**Re: Cottonwood Crossing II Lots 2A & 2B at 10088 and 10080 Coors Blvd SE
Erosion and Sediment Control Plan
Engineer's Stamp Date 4/8/24 (B14E010D)**

Based on the information in your submittal, received on 9/16/24, the ESC Plan and NOI cannot be approved for Building Permit or Work Order until the following comments are addressed.

EROSION CONTROL PLAN

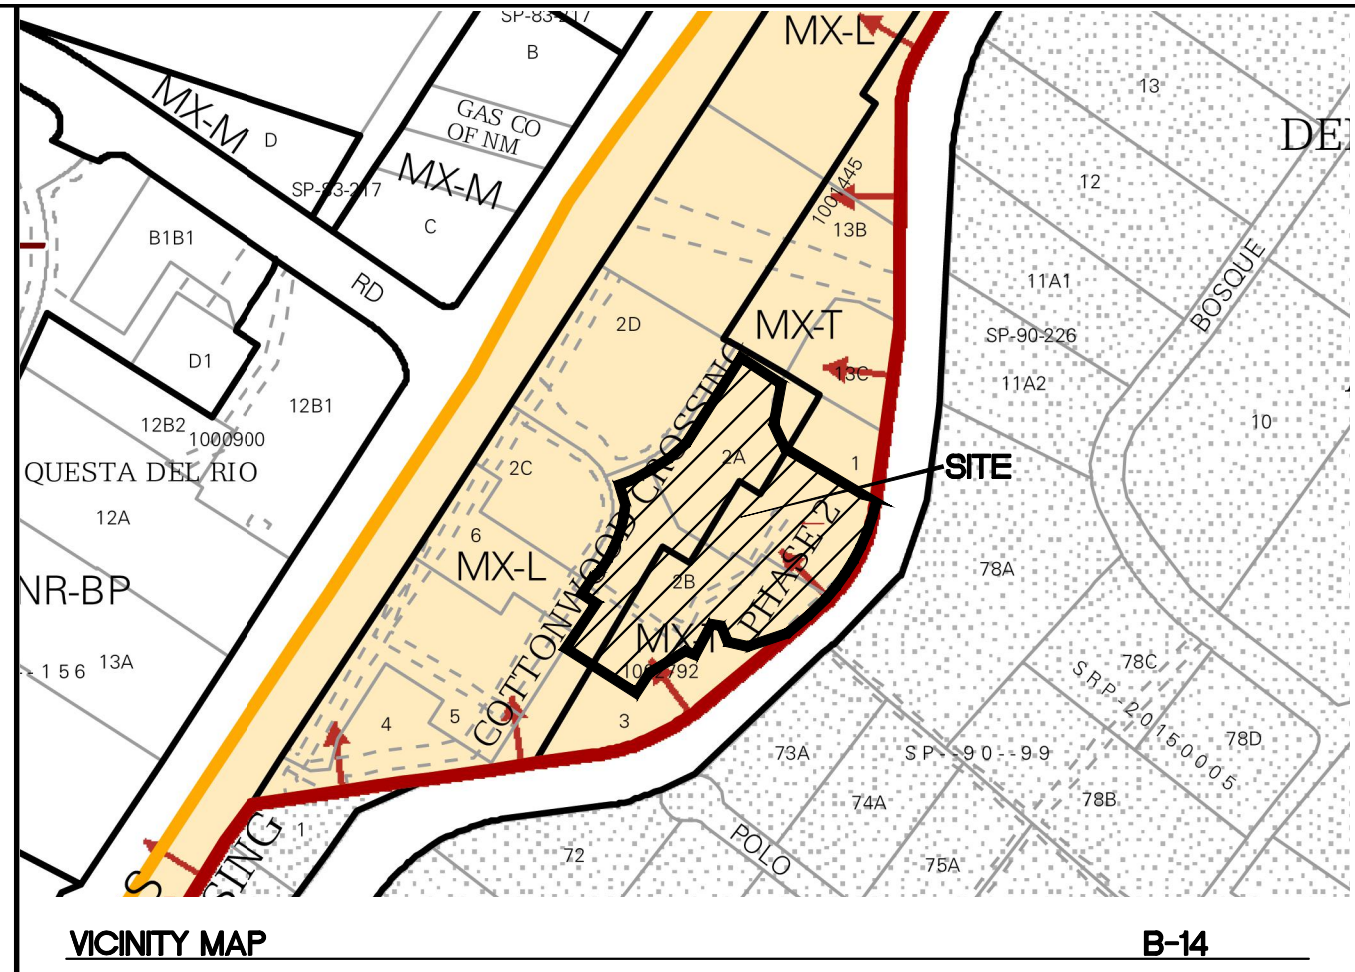
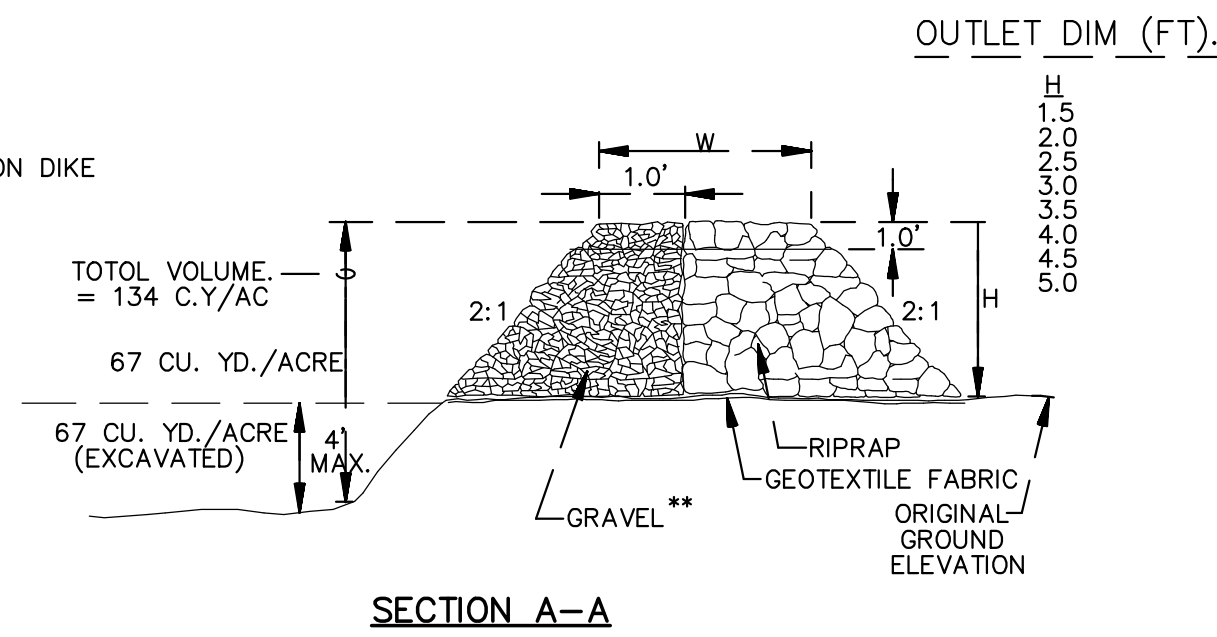
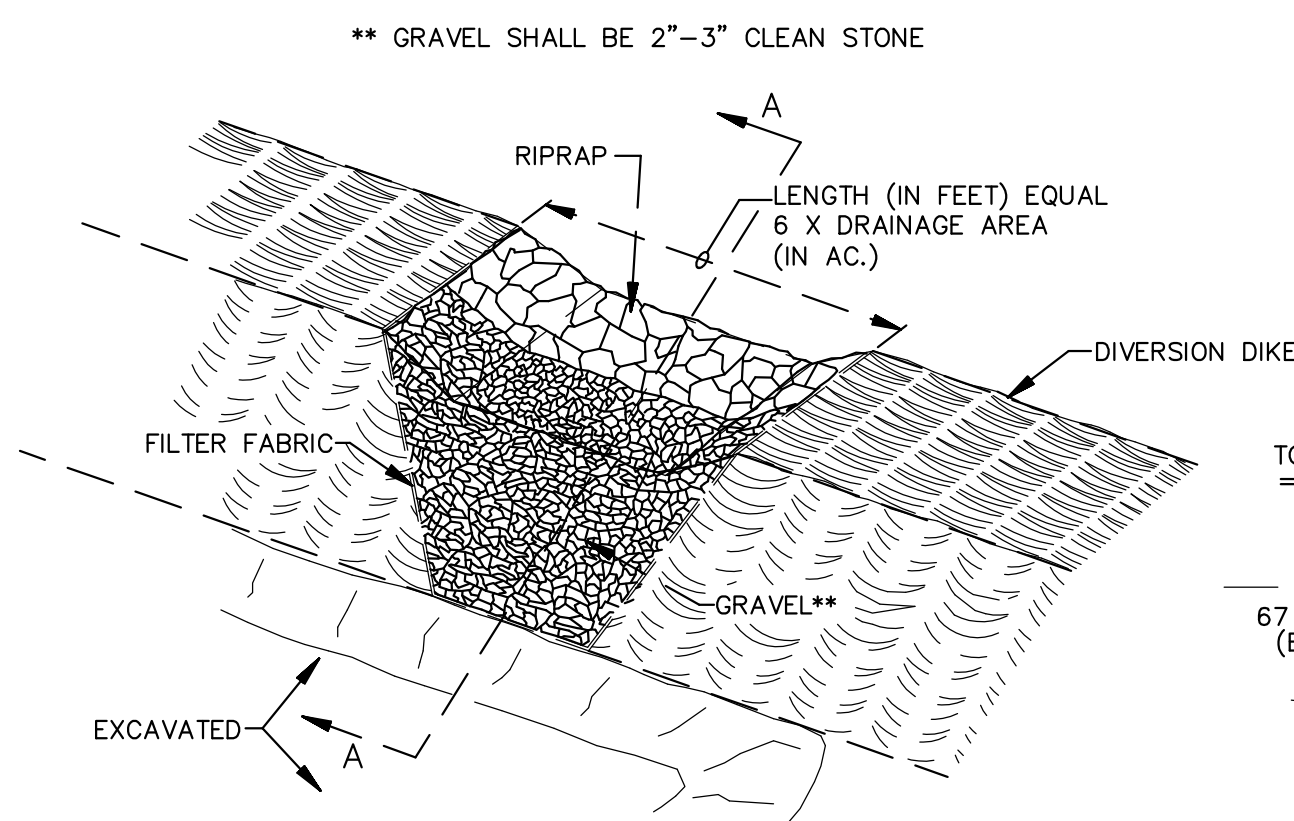
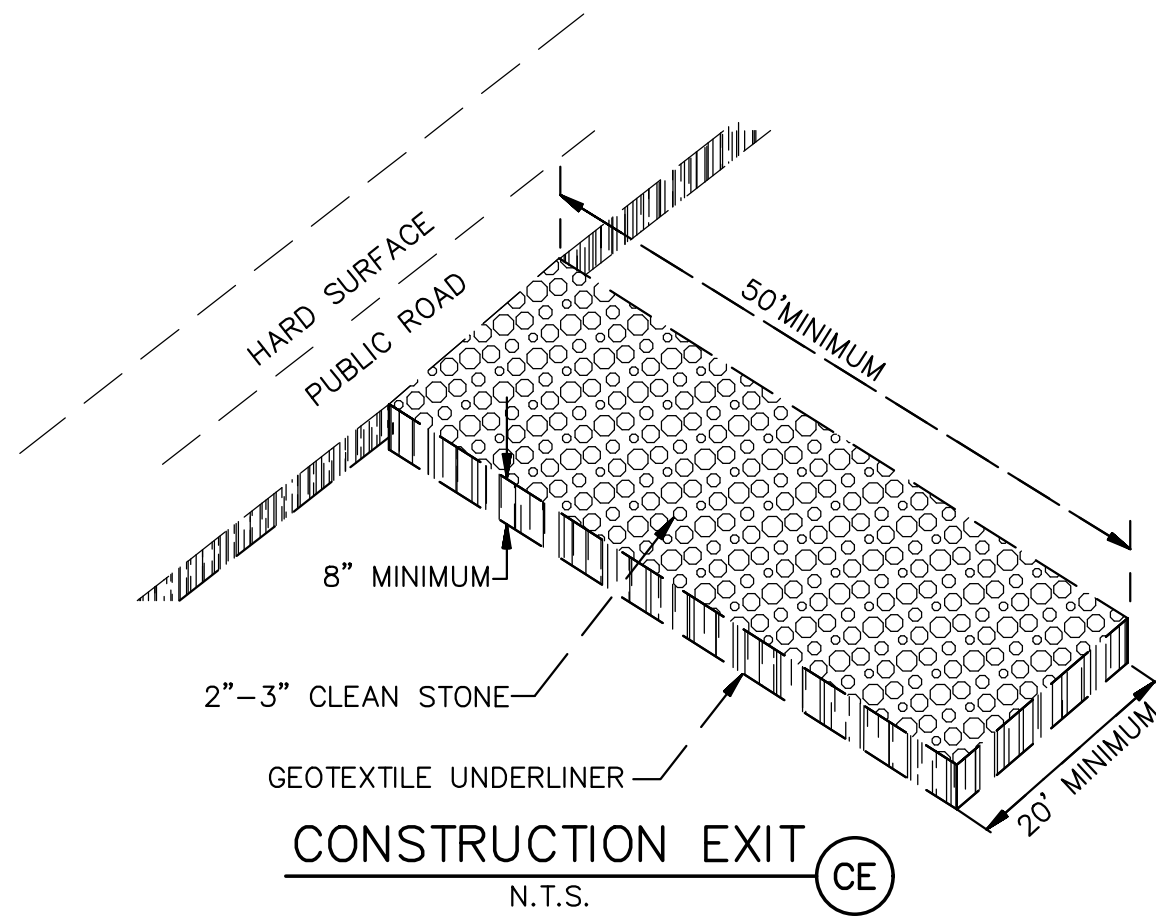
1. The ESC Plan can't be approved until after Hydrology approves the G&D Plan for each specific purpose, Site Plan, Grading, Building Permit, and Work Order. Hydrology hasn't approved the G&D Plan for any purposes yet, so this plan can't be approved for any purpose. This conceptual plan is missing the level of detail required for ESC Plan approval, including:

- a. Lot Numbers are missing from the ESC Plan and must be added per the ESC Plan Checklist.
 - b. Proposed grades and drainage patterns are missing from the ESC Plan and must be provided per CGP 7.2.4.b.

- c. The north arrow is pointing west and must be corrected per the ESC Plan Checklist.
 - d. Sheet numbers and City Standard notes are missing and are required.

3. Under existing conditions, this site receives stormwater runoff from the rest of the CPODS (lots 2C, 2D, 4, 5, and 6 plus half of Coors Blvd.), and this site discharges concentrated flows into two existing storm drain inlets on the south side of this site. Ponds and berms are required per the ESC Plan Checklist since the discharge is concentrated and the drainage area is more than 5 acres. Please consider designing controls for two separate phases, Work Orders as Phase 1 and Building Permits as Phase 2 as follows.

- a. During Phase 1, an onsite sediment basin (SB) will be sized for the entire area draining to it, not just the disturbed portion of the site, in accordance with CGP 2.2.12.

- b. Phase 2 will start after stormwater runoff from the offsite portions of the watershed has been conveyed in a non-erosive, lined drainage system consisting of paving, C&G, and storm drain. During Phase 2, the SB will be removed, and a silt fence will be added around the low sides of the remaining disturbed portions of the site to prevent sediment

- and pollutants from entering the lined conveyance system. The silt fence must be “on contour” with the ends turning uphill. Additional berms and ponds will be necessary for any concentrated discharge points into the lined system.
- c. New ESC Plans must be submitted to the city for any lots transferred to new owners/operators.
 4. Care should be taken to prevent concentrated flows adjacent to the existing block wall along AMAFCA’s lot. Complaints were received by the city several years ago saying that erosion damaged some of AMAFCA’s walls. Locate additional berm/swales along the south and east boundary to divert stormwater into the STs non-erosively.
 5. The Engineers Stamp has several different dates on each sheet. Update the Engineer’s stamp date on all sheets when changes are made to any of the ESC Plan sheets.
